LSC TRANSPORTATION CONSULTANTS, INC.
545 East Pikes Peak Avenue, Suite 210
Colorado Springs, CO 80903
(719) 633-2868
FAX (719) 633-5430
E-mail: lsc@lsctrans.com
Website: <http://www.lsctrans.com>

MEMORANDUM

SUBJECT: Lorson Ranch East
(PUDSP-16-003) Review 2
Response to Comments Memorandum
LSC #164360

Following are the LSC Transportation Consultants, Inc. responses to the August 15, 2017 El Paso County Planning and Community Department comments letter regarding the July 12, 2017 Updated Traffic Impact and Access Analysis by LSC.

**Approach 3**  
**WB-50 AutoTurn Movements**  
Lorson Ranch East Roundabout (LSC #164360)

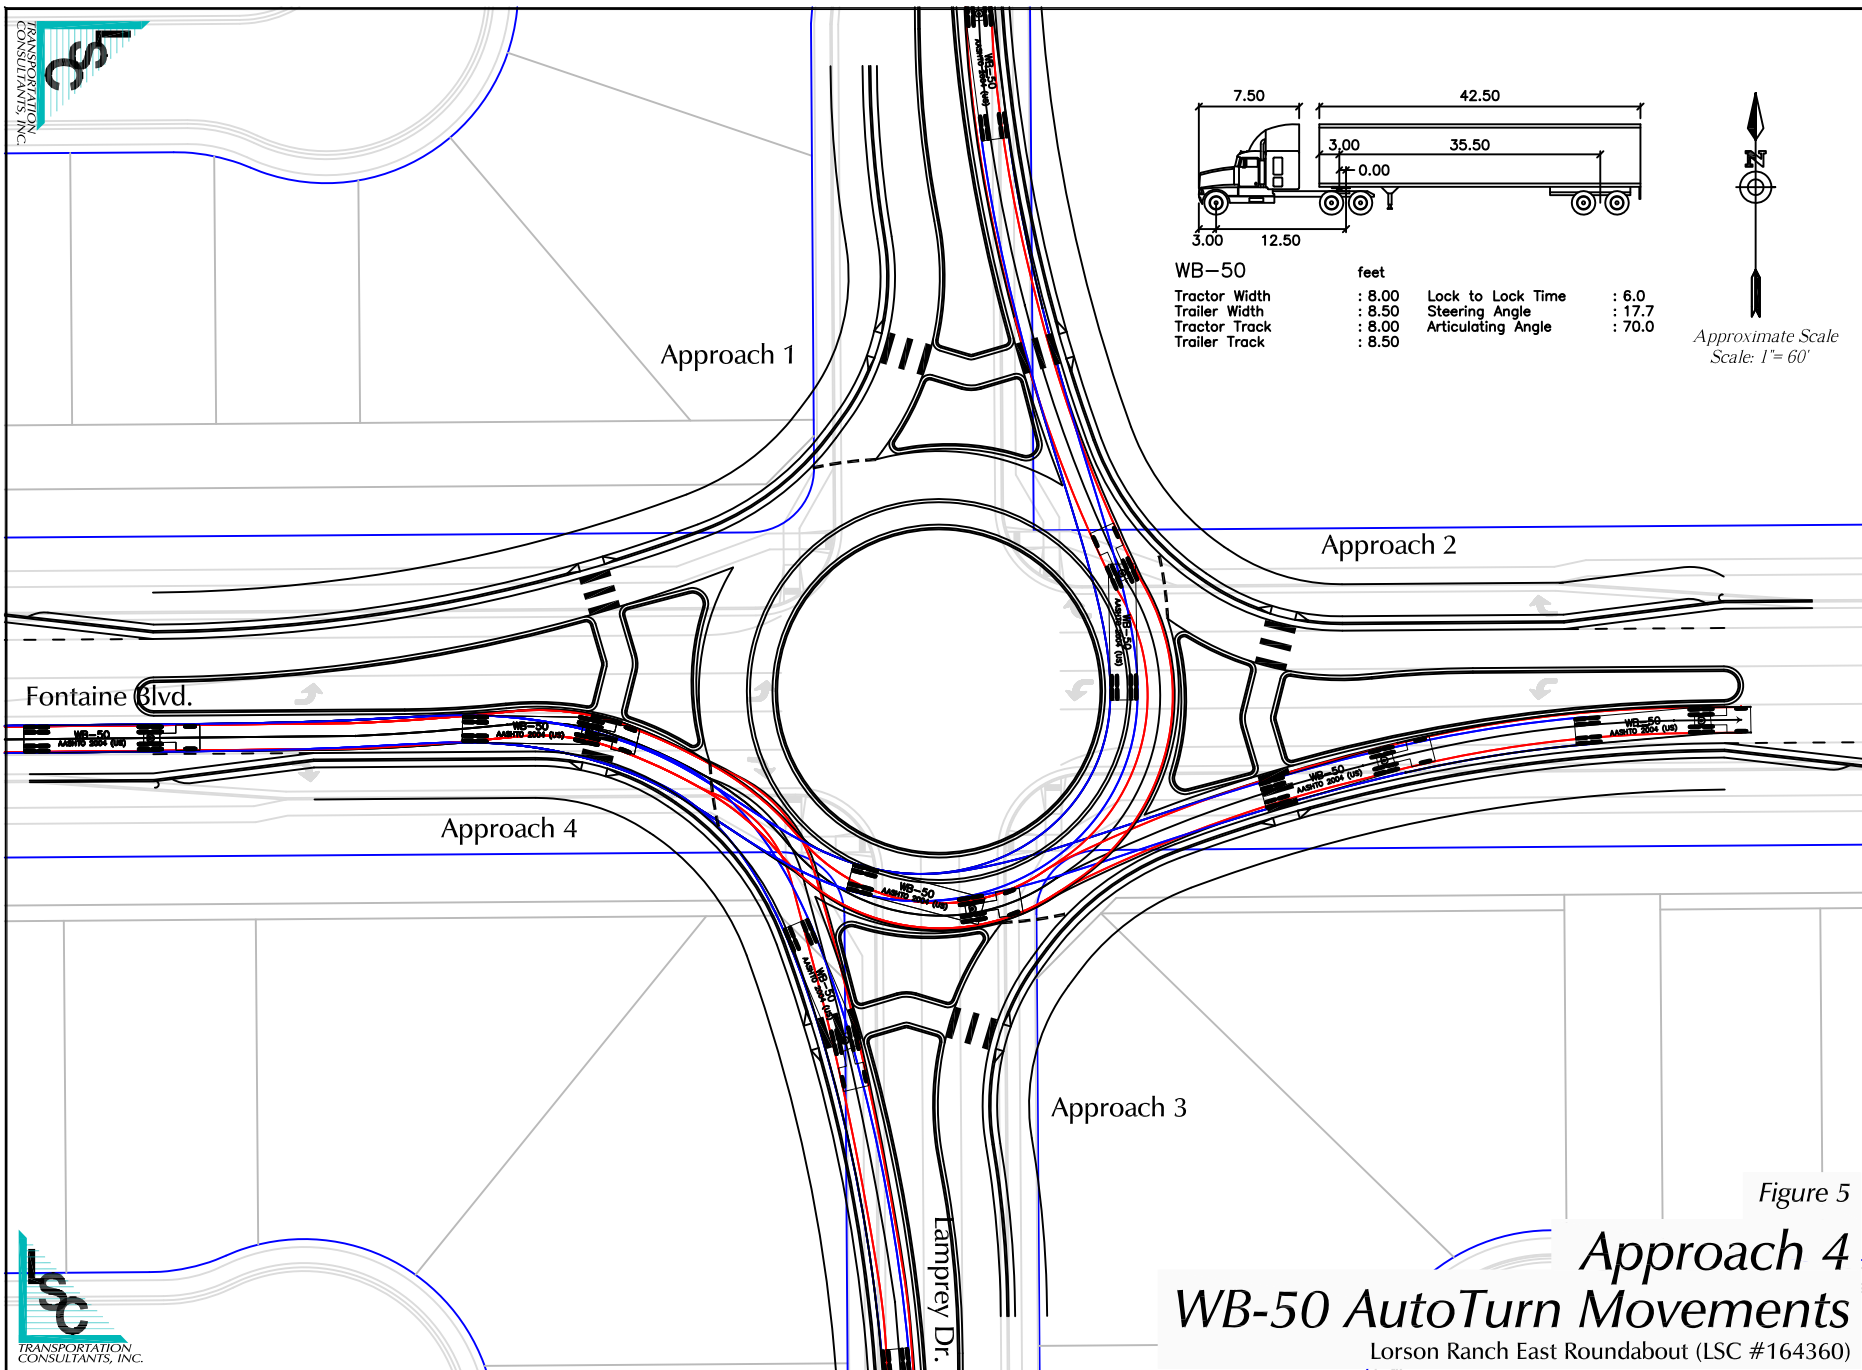
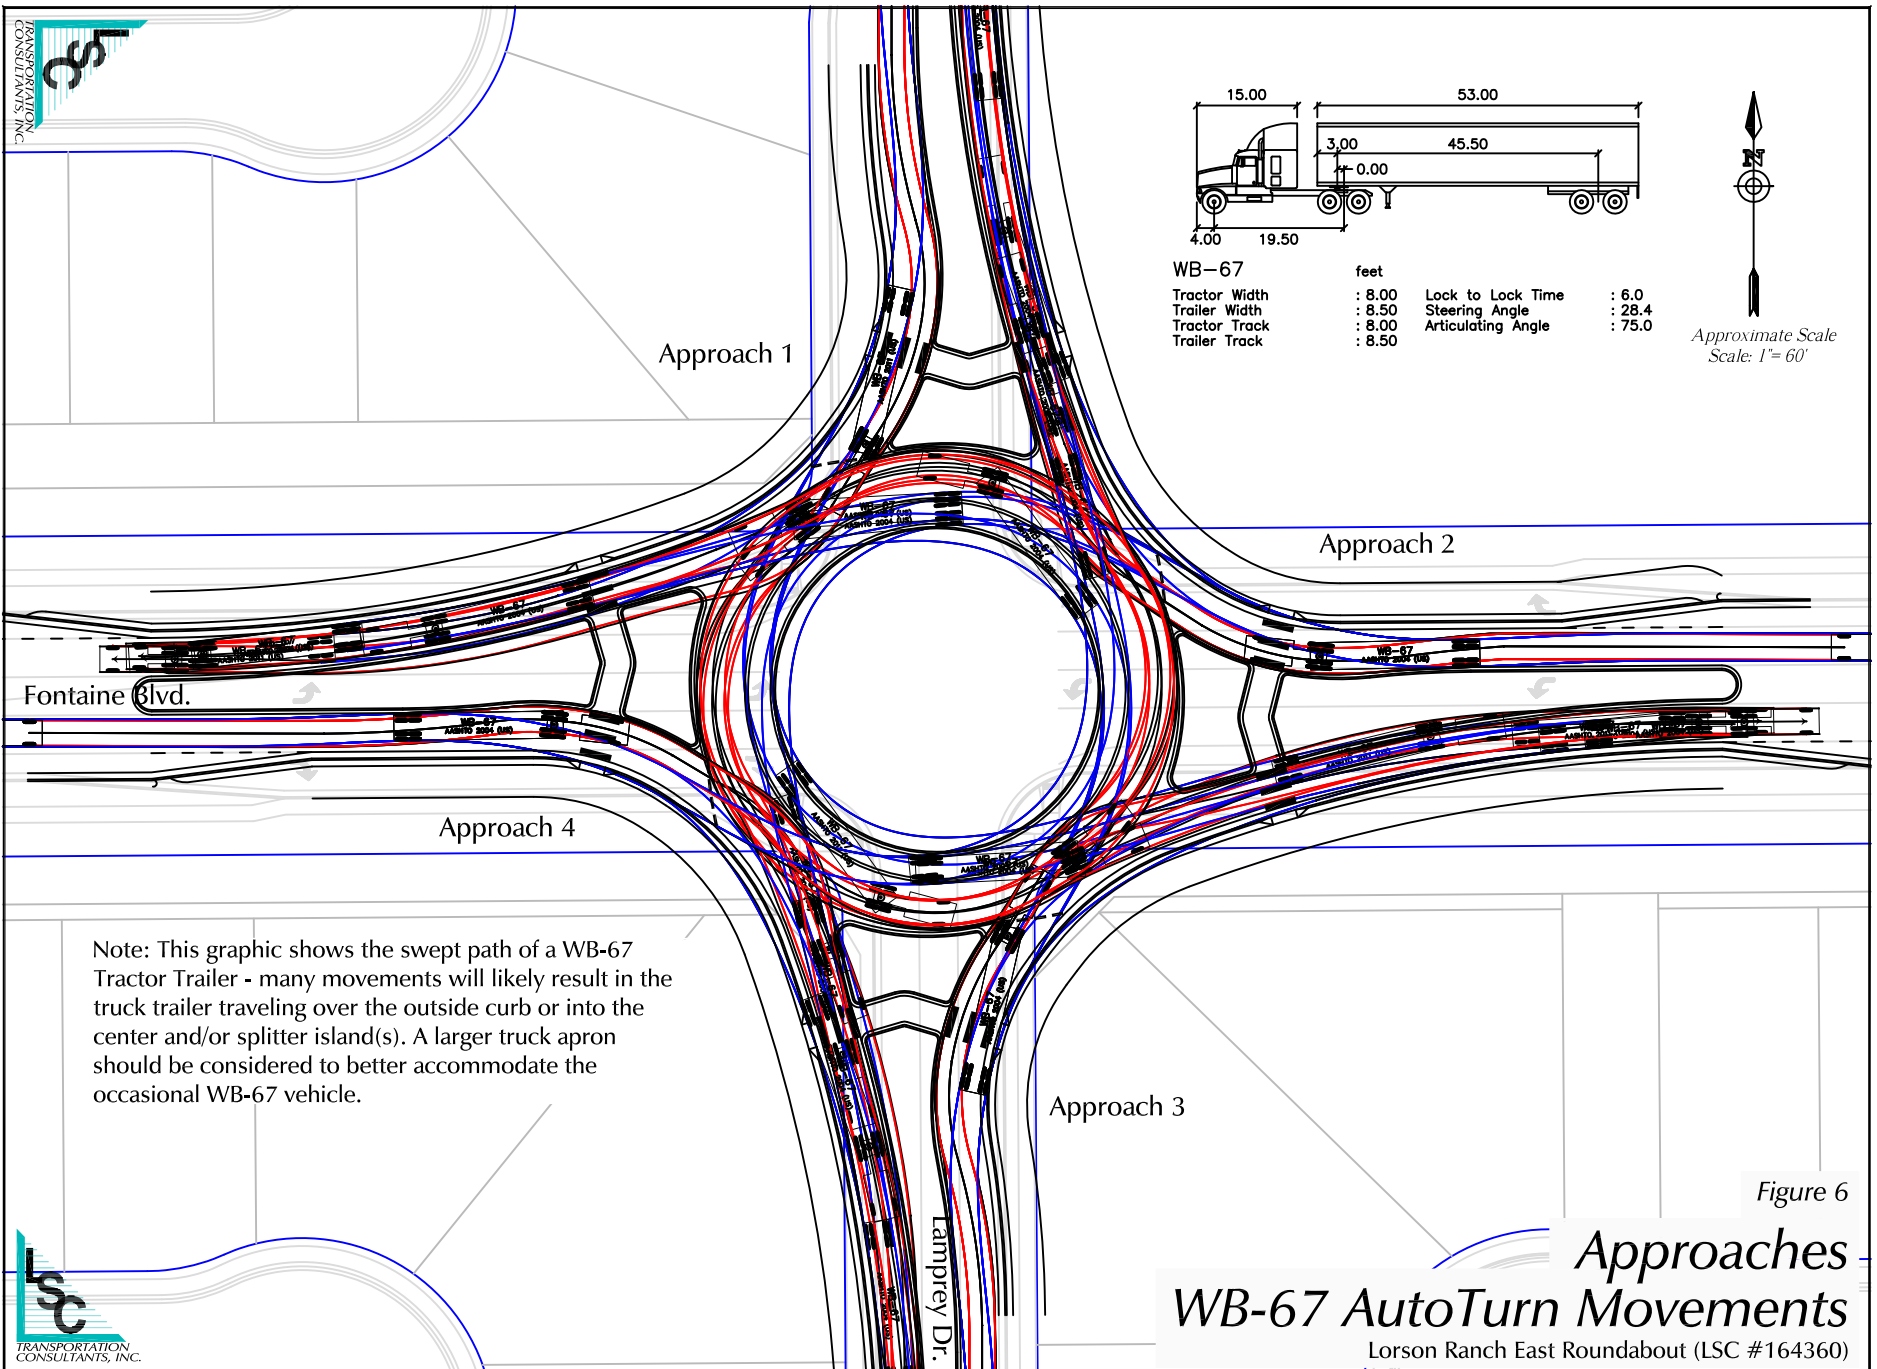
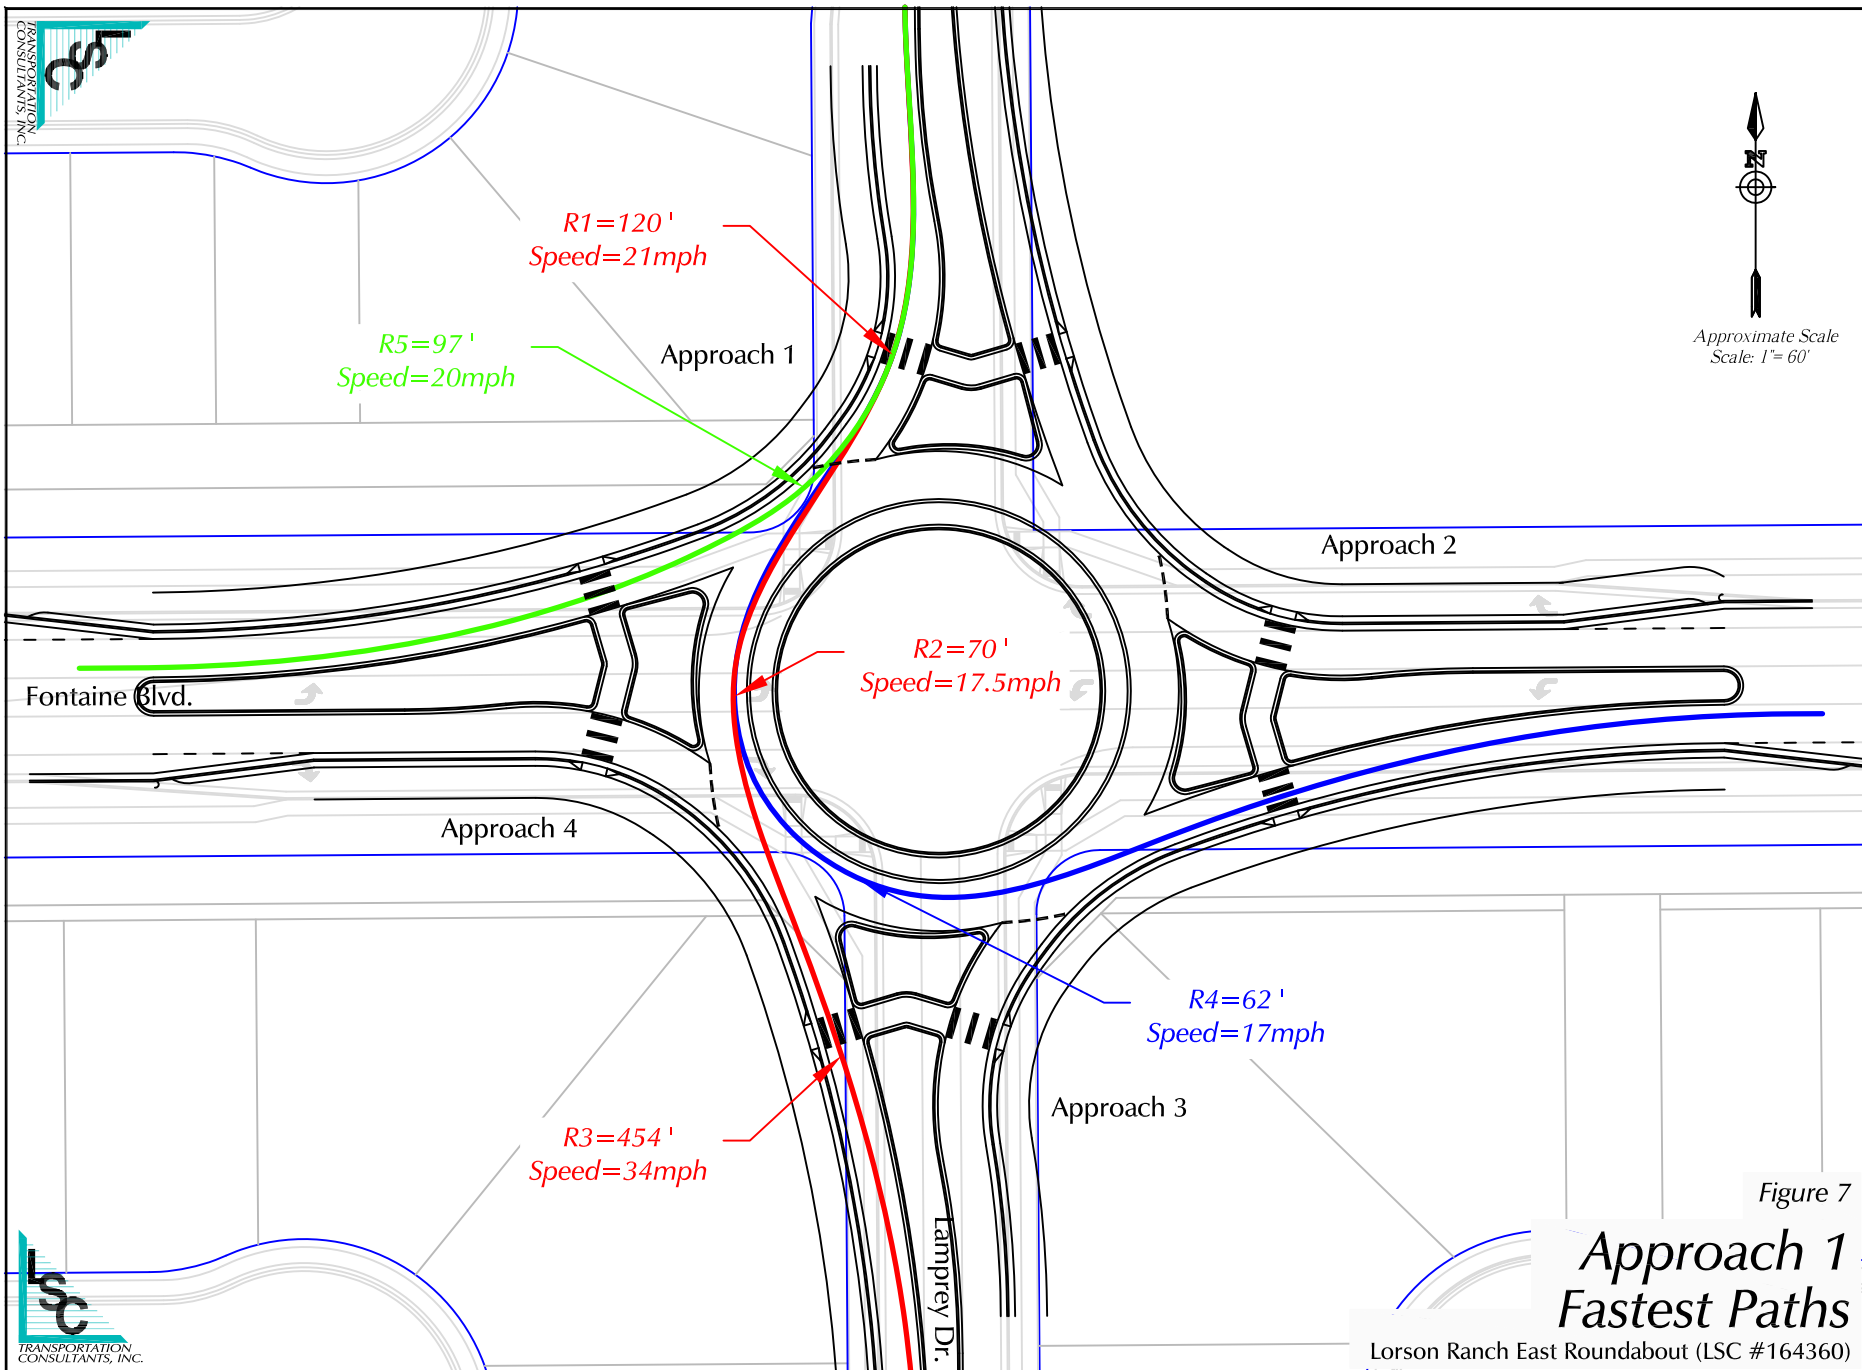
8. *Regarding the e-mailed comments dated March 17, 2017:*
*a. **It needs to be clearly documented that the roundabout is the proposed intersection at Lamprey/Fontaine. If the roundabout is the chosen option, could it not be designed to be expandable to 2-lanes when necessary along with widening of Fontaine Blvd.?***

LSC Response: The updated TIS clarifies this and clearly presents the roundabout as the proposed solution. The report also includes a roundabout design report and exhibits with the design of a future two-lane roundabout.
